From: lloyd willson [REDACTED]
Sent: 14 November 2011 19:10
To: Katherine Rawlins; Harry Bud 11 Ivydale
Subject: RE: BR/249/11/
Importance: High

I refer to the above planning application at 11 Ivydale Road, Bognor Regis, PO21 5LX for the addition of extensions and dormer windows.

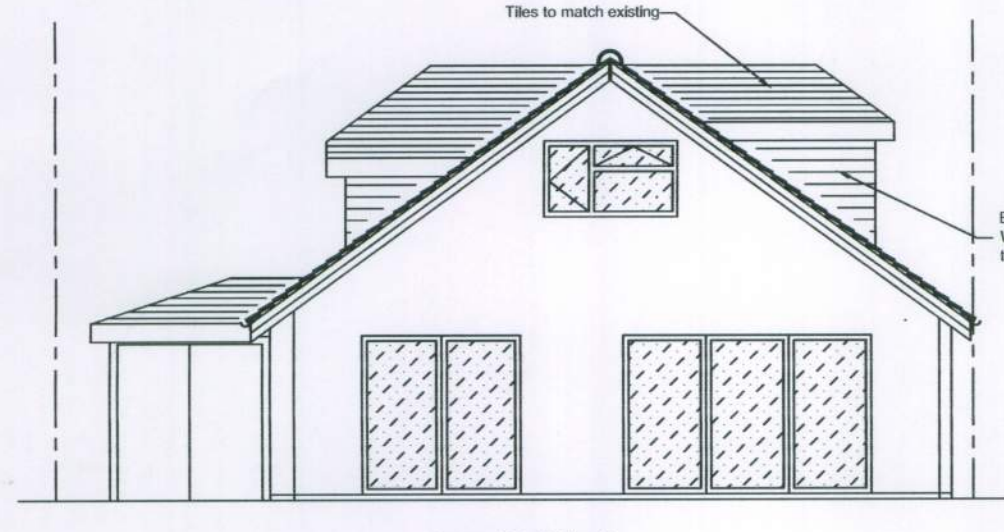
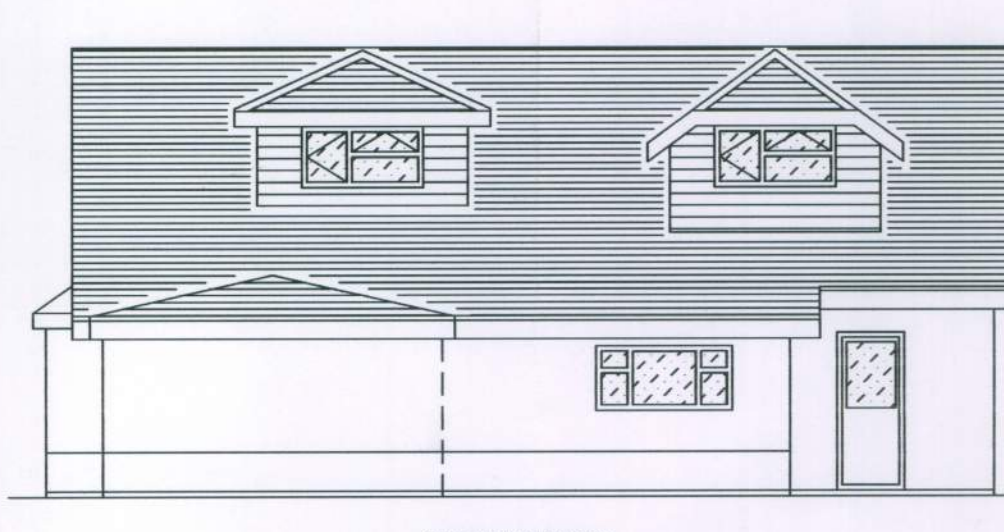
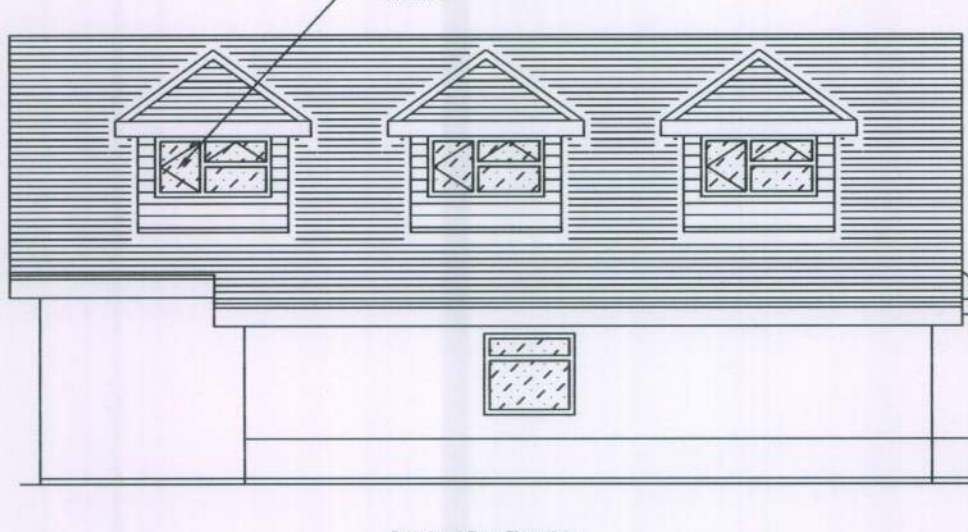
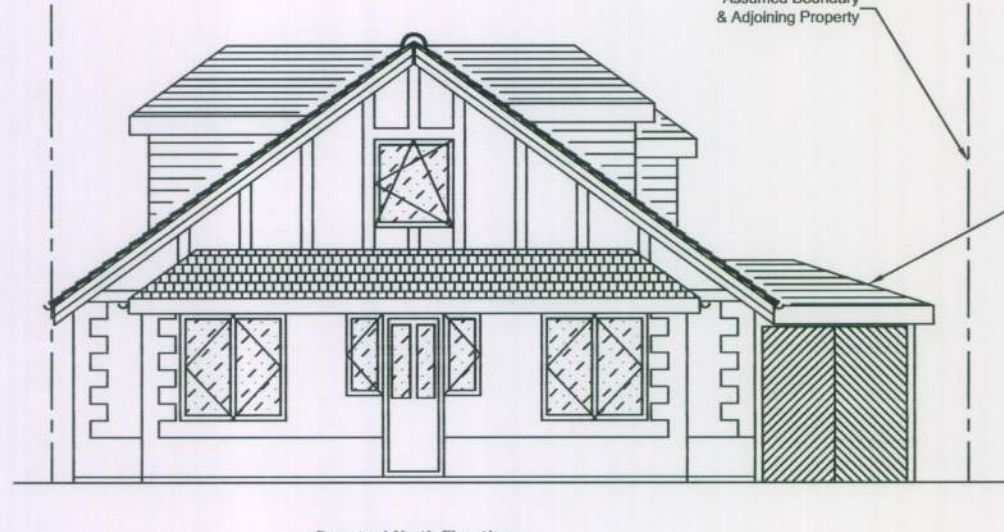
Having discussed the application with my Team Leader, the proposed front and rear extensions, and the addition of dormer windows are considered acceptable in design and visual amenity terms. However, the proposed side extension with a hipped roof adds significant bulk and massing to the property and is considered unacceptable in design terms. From the submitted floorplans the garage at ground floor level is extremely narrow in width and would be unable to accommodate a car.

Please could you therefore amend the drawings by omitting the side extension and inserting an additional hipped roof dormer window on the west facing roofslope. On receipt of amended plans, the officer recommendation will be to approve the application.

I will be addressing the issue you have raised with my client and will forward the amended plans asap.
